Applicant: Mr Kasim Siddique

Description: Demolition of existing side extension at 102 Sackville Street and erection of 2no bungalows to rear with associated works

Site Address: 102 Sackville Street, Barnsley, S70 2BX

Recommendation: Refuse

102 SACKVILLE STREET
ELEVATIONS

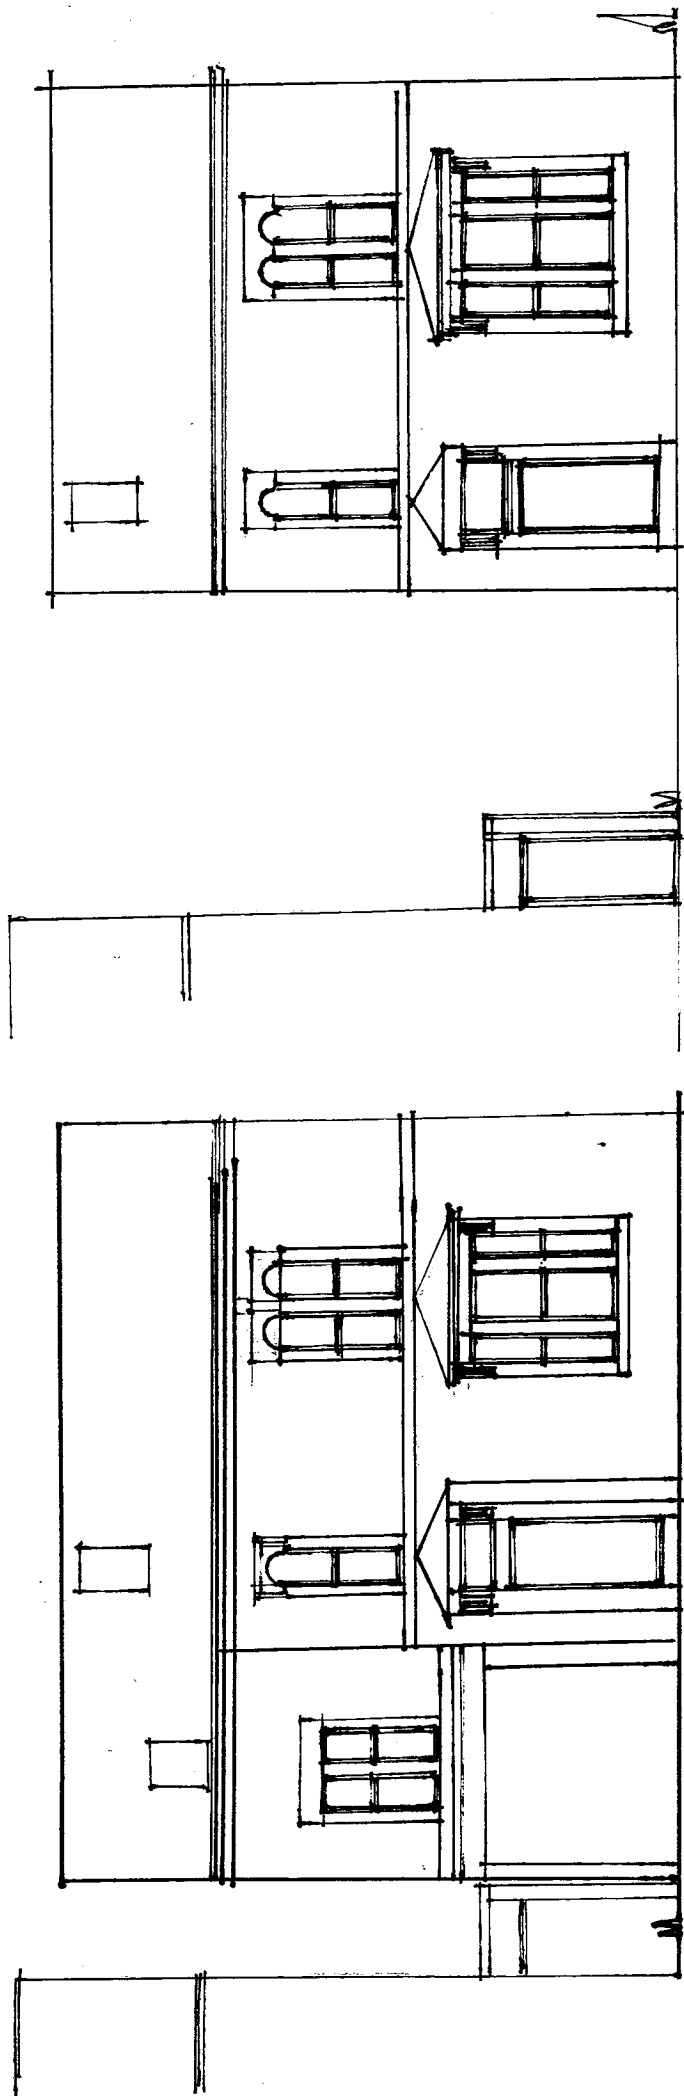
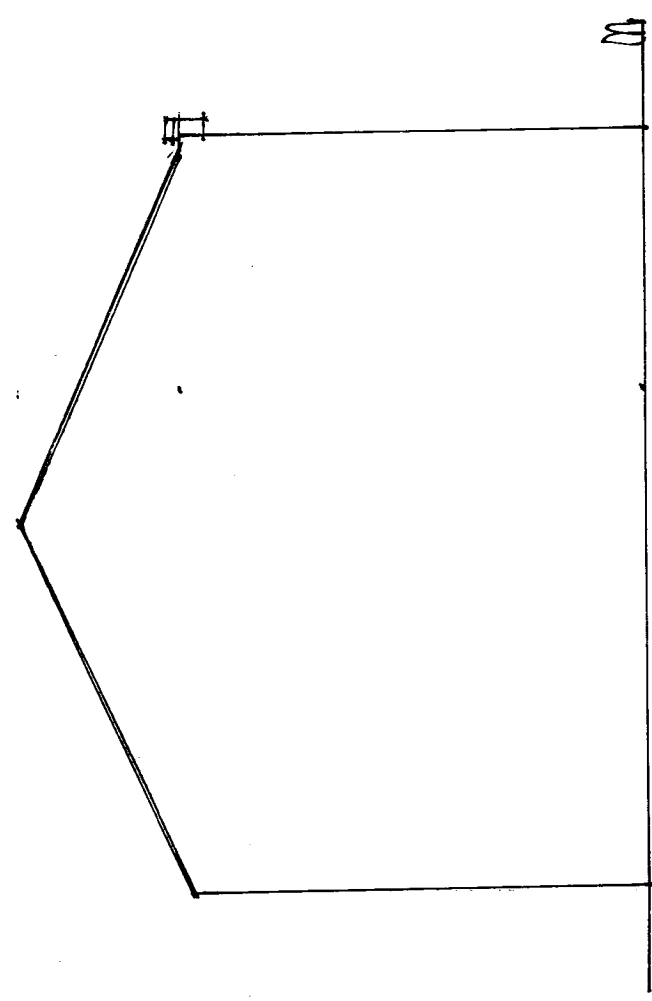
This application proposes an increase in width of the shared access to 3.2m by demolishing the existing extension which sits above the access. However, Highways DC would expect a shared driveway onto a busy road to be a minimum of 4.5m (at least for the first 10m off the public highway) to remove the requirement for vehicles to stop on the road waiting to turn in. In addition, should this application be approved, vehicles from five different dwellings would be requiring access along this narrow track and the increase in potential conflicting movements would not be acceptable.

LAYOUT PLAN

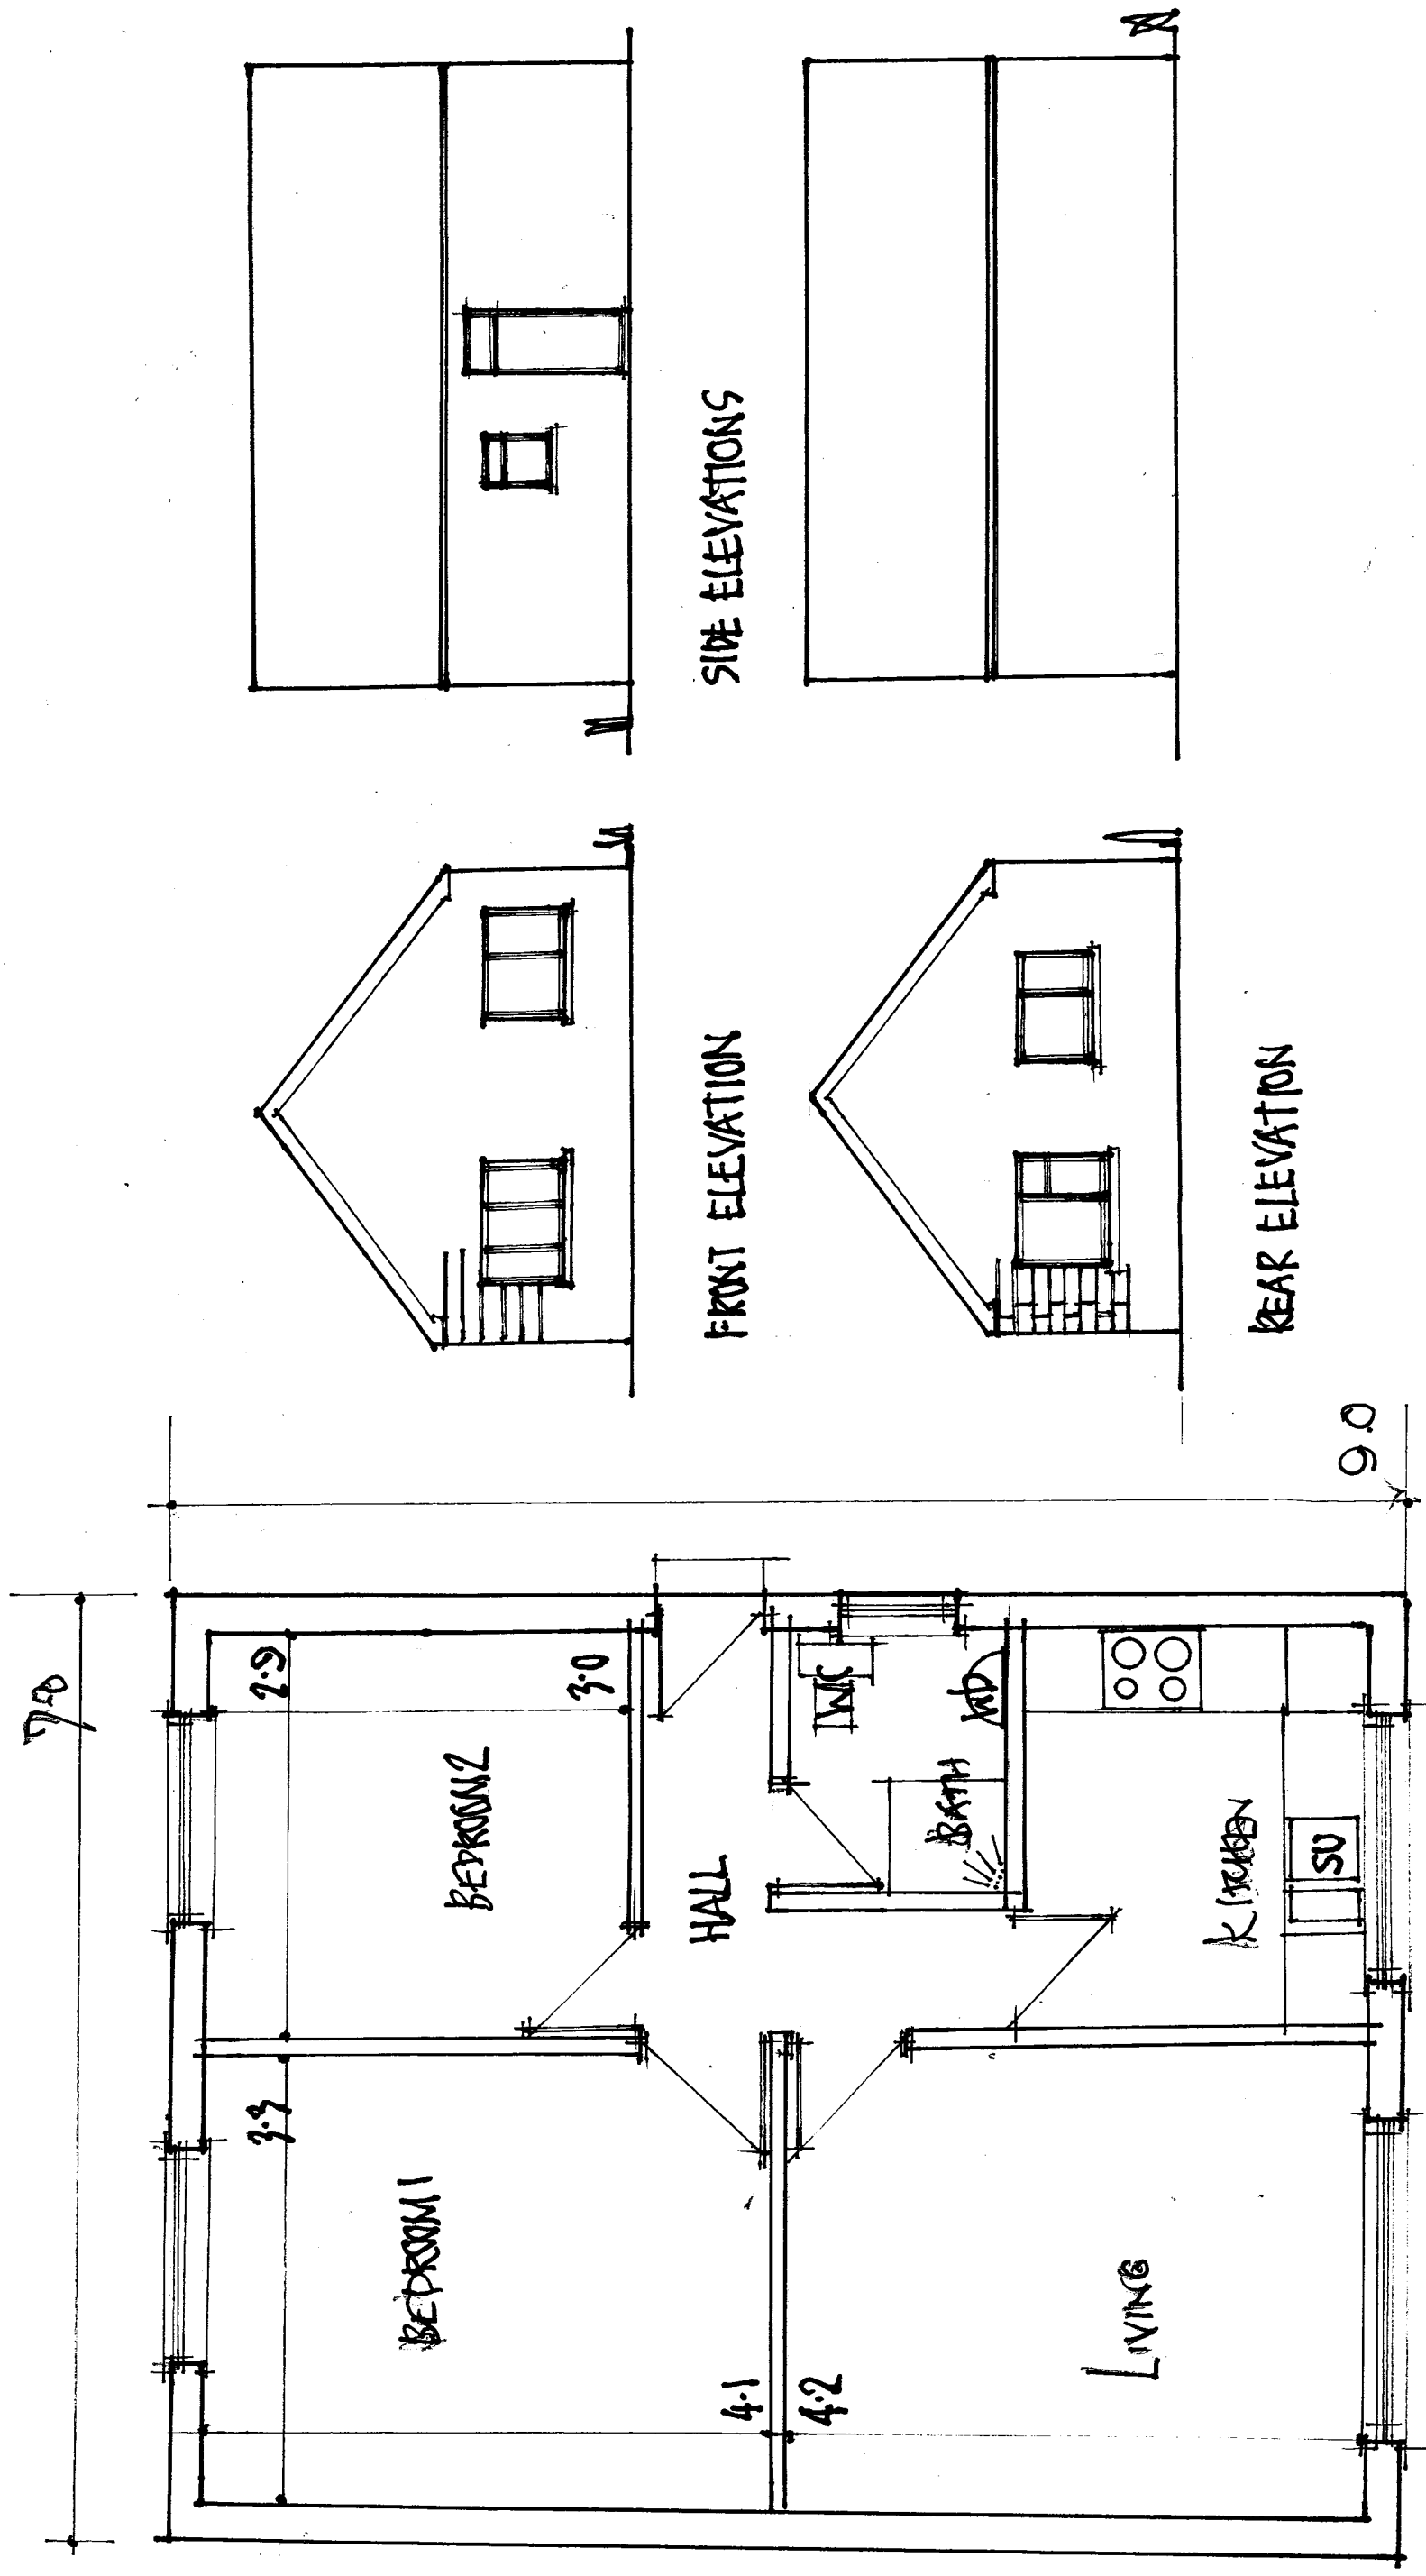
The proposed side elevation of the northern most bungalow would be less than 7m from the rear elevation of number 100 which falls short of the 12m requested in the SPD. Furthermore, the side elevation would be circa 1m from the majority of the rear boundary of number 100 which serves its private amenity space. Limited information has been provided regarding the proposed levels of the bungalows so it is difficult to determine the level of overshadowing and overbearing impact. At present the site is a lot higher than the neighbouring property given that earth and rubble has been piled on it.

The side elevation of the Southern most bungalow would be over 21m from the rear elevation of the properties fronting Loxdale Garden, although it should be noted there is a significant level difference between the two sites with the application site being higher. Again limited level information has been submitted with the application to fully assess the impact on the neighbouring private amenity spaces.

In term of the future residents of the bungalows, the living/dining room falls short of the 17m² required by the South Yorkshire Residential Design Guide and the kitchen measures circa 7m² whereas the requirement is 11m². As such, the level of accommodation would be substandard and detrimental to the amenity of the future residents, contrary to Local Plan Policy GD1.

The South Yorkshire Residential Design Guide Appendix 4 section B1.1.11 also states that the maximum length of an access without a turning facility suitable for a fire appliance is 20m. This access measures approximately 36m.

Furthermore, the South Yorkshire Residential Design Guide cites a minimum clearance of 6.0m from a parking space to allow vehicles to manoeuvre in and out of the bays without obstruction. The bays for the north-easternmost plot do not have anything like this amount of manoeuvrable space and do not look accessible at all, especially if application 2019/0716 was built out in accordance with the approved plans.
